Re: Starlite Heights and Tamarack Ridge Environmental Comments

From: the simon [thesimon@inlandnet.com]
Sent: Thursday, November 15, 2007 5:40 PM
To: donvaloff@co.kittitas.wa.us
Subject: comments on SEPA for projects Meadow Springs P-07-15, Starlight Heights P-07-16, Tamarack Ridge P-07-18

From: Paula J. Thompson DVM [thompson@fairpoint.net]
Sent: Thursday, November 15, 2007 3:07 PM
To: Dan Valoff
Subject: Meadow Springs PBC Preliminary Plat - P-07-15; Starlite Heights PBC Preliminary Plat - P-07-16;
 Tamarack Ridge PBC Preliminary Plat -P-07-18 SEPA Comment

RE: Notice of Application Performance Based Cluster Preliminary Plat:

SITE PLAN
OF
STARLITE HEIGHTS
A PORTION OF SECTION 01, TOWNSHIP 19 N., RANGE 14 E., W.M.
KITTITAS COUNTY, WASHINGTON

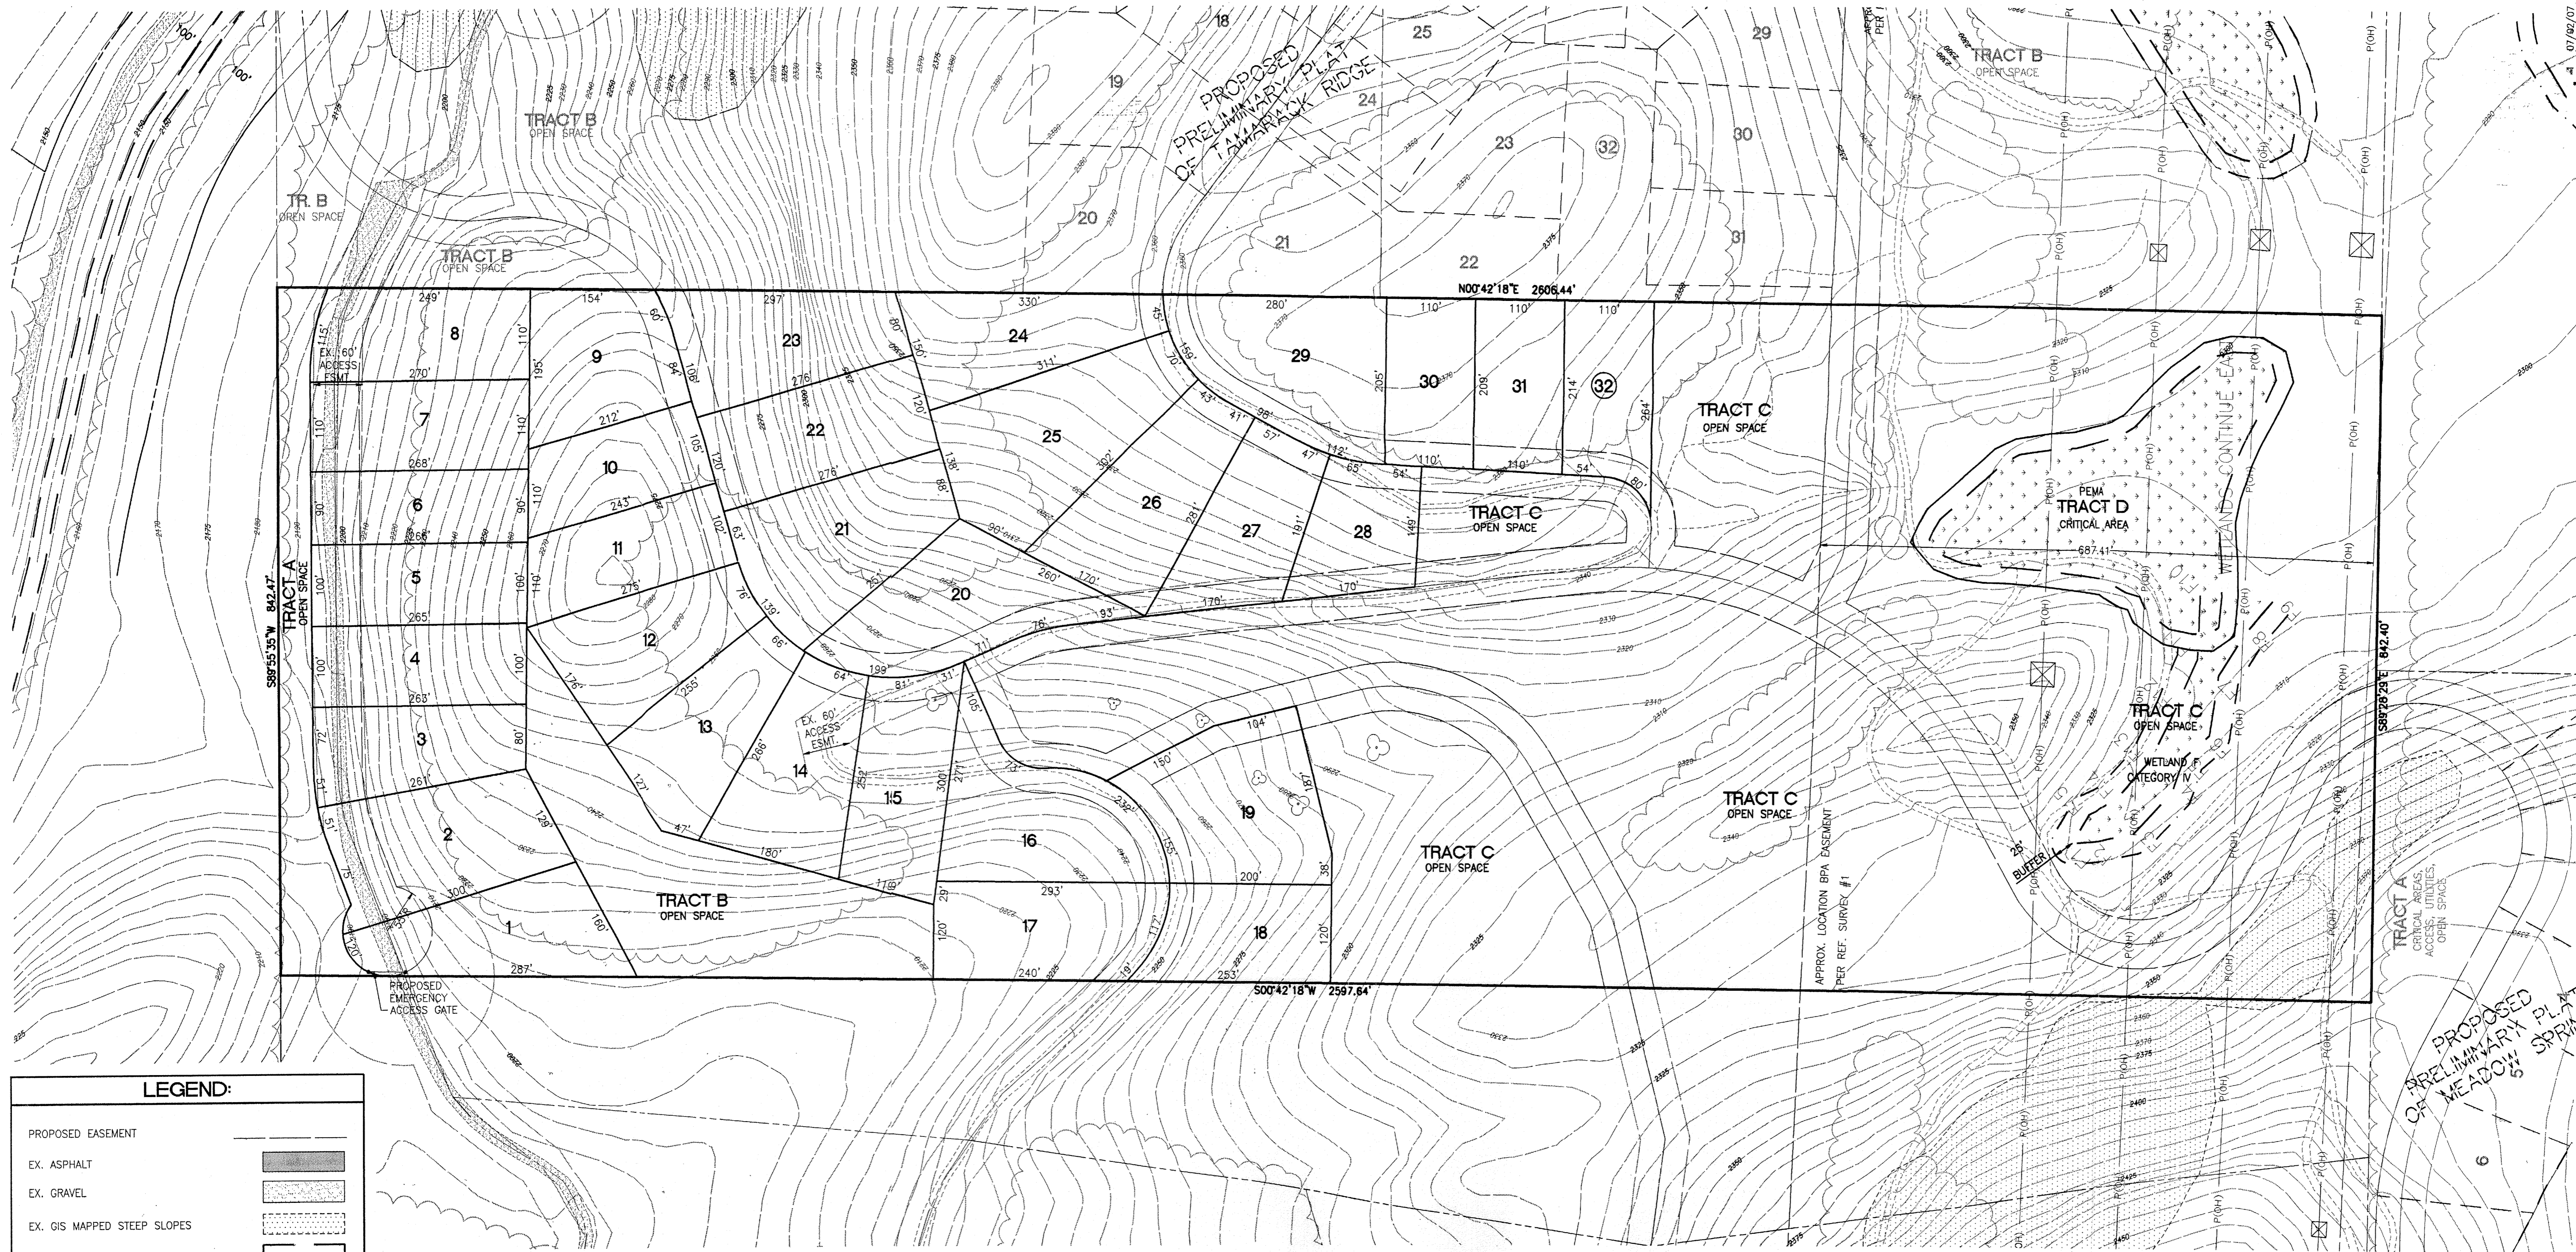
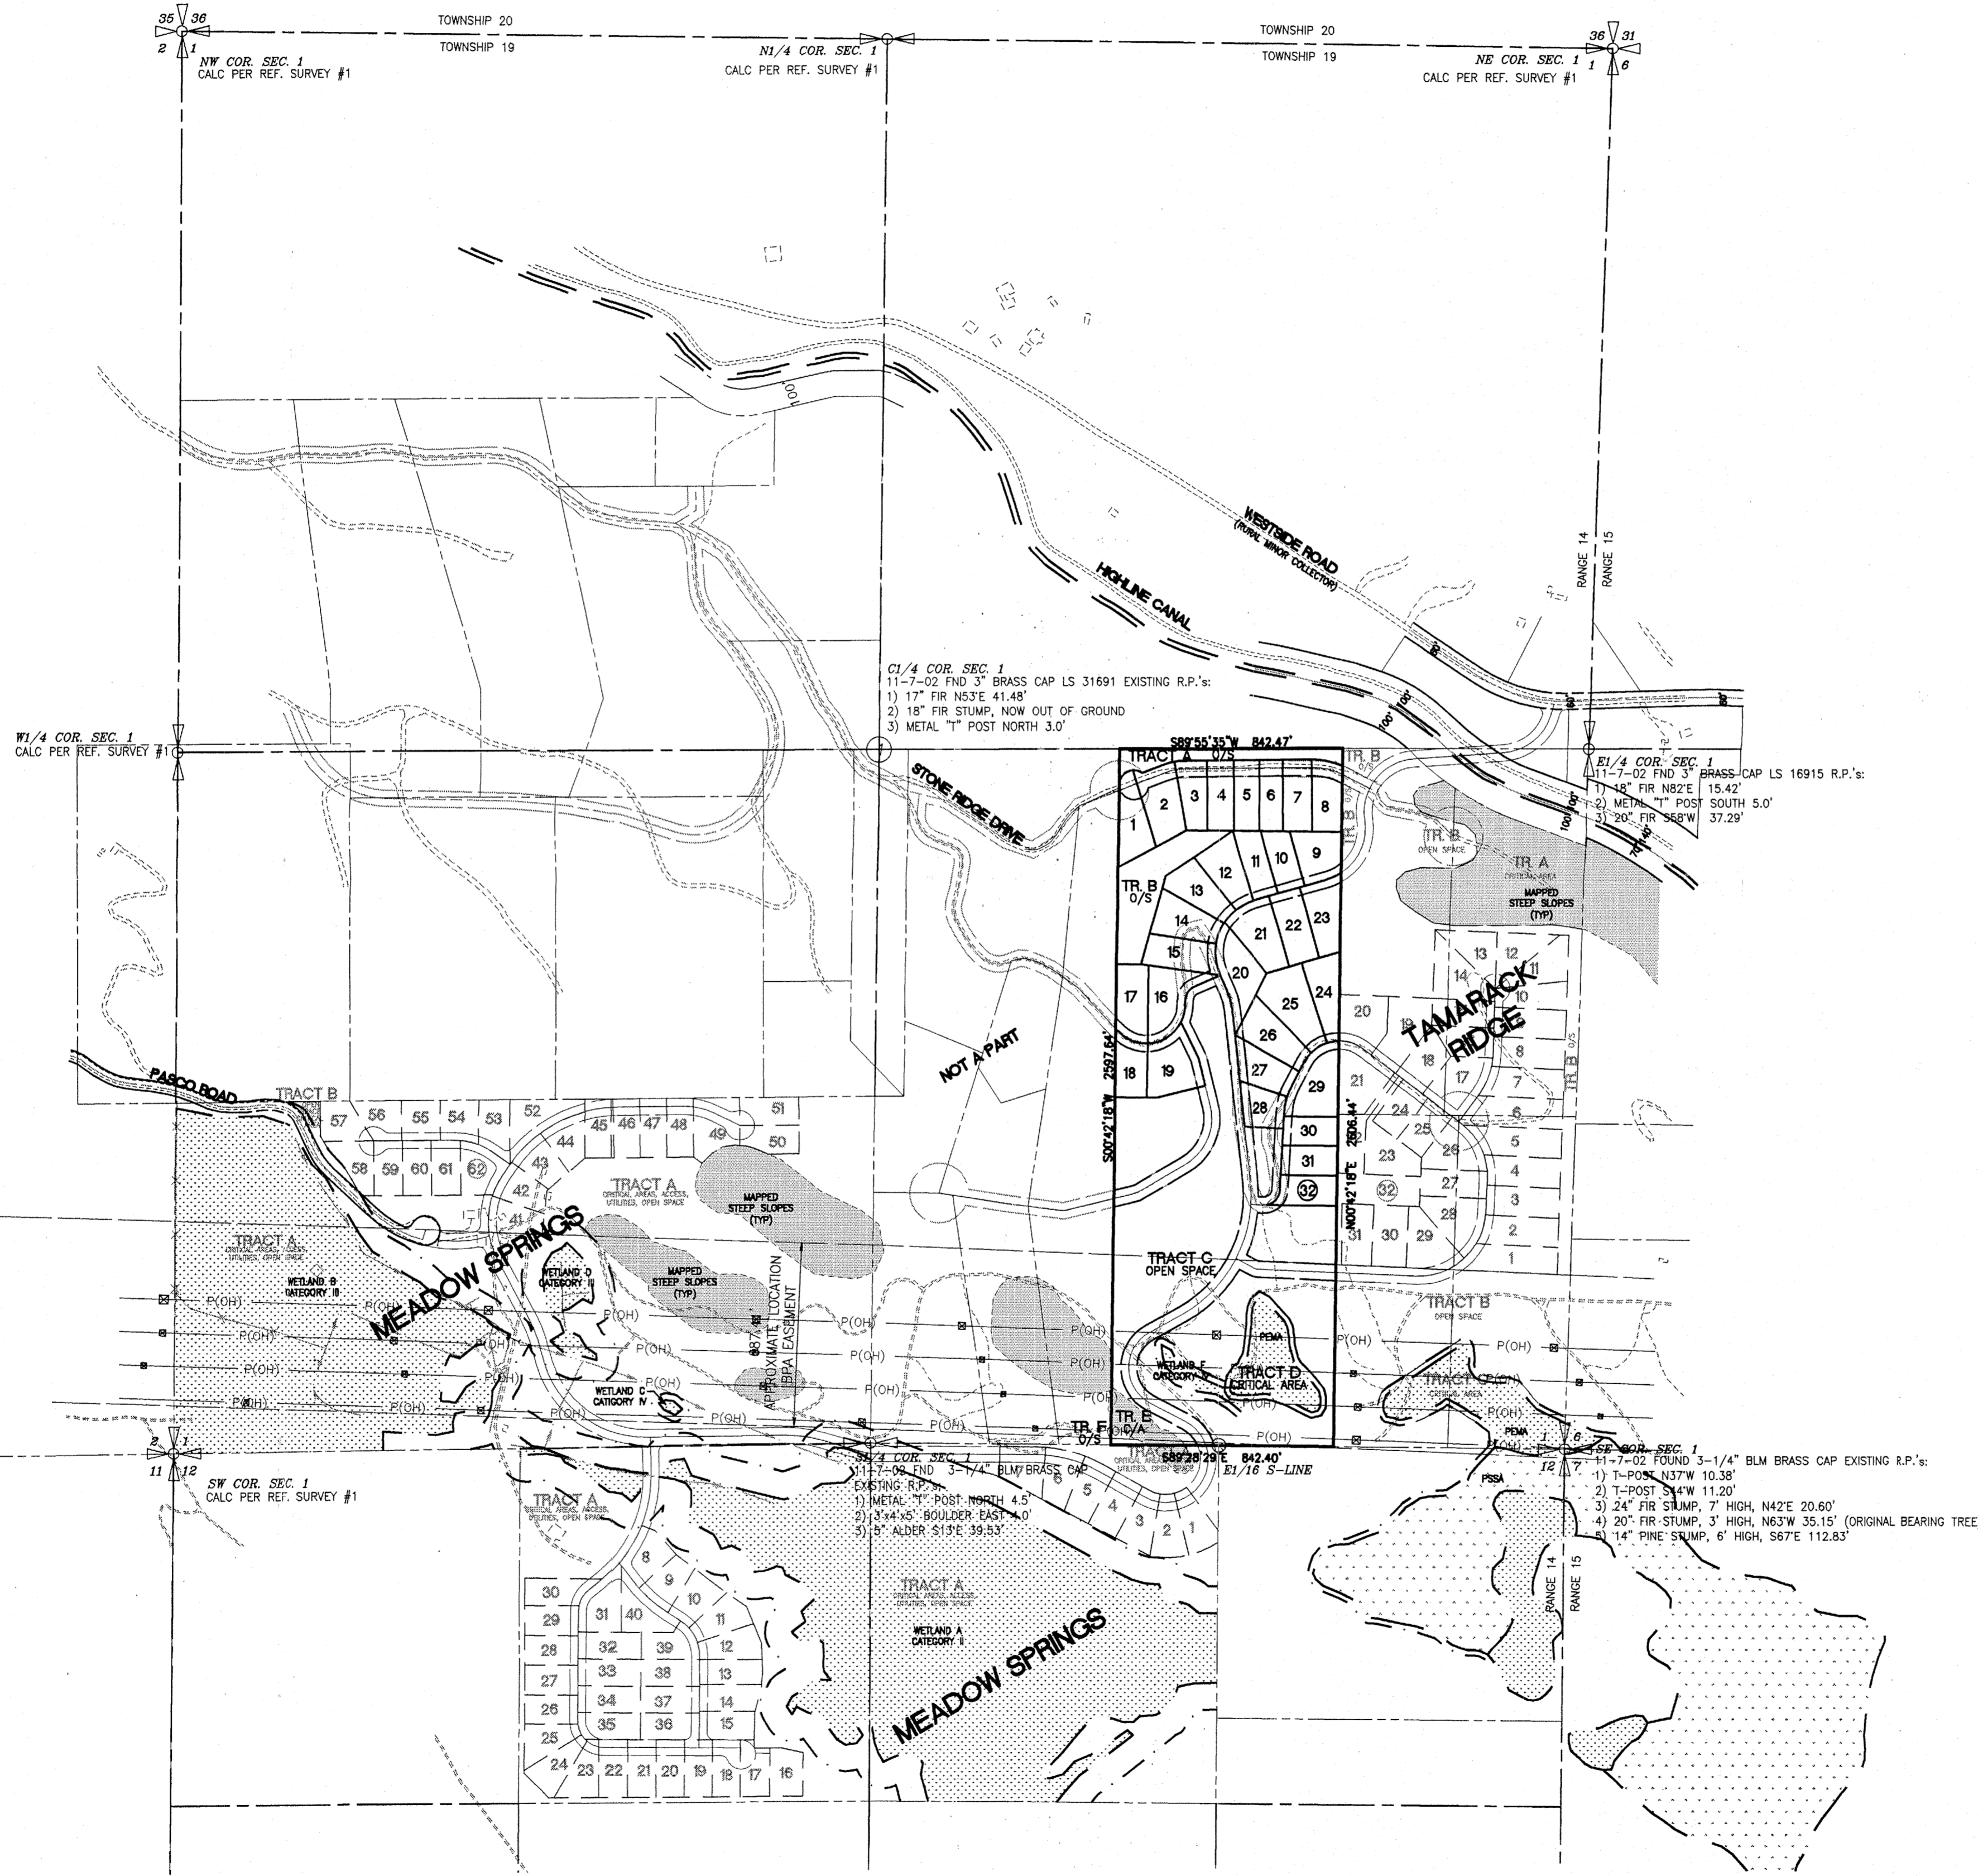
- Page 6, B. 5. c. & d. The three open spaces shown on the maps are non-contiguous and composed of steep slopes and critical wetlands. Reducing the number of homes to the number that the land is currently zoned for will allow considerably improved open space for the deer and elk herds which are native and common to this area.
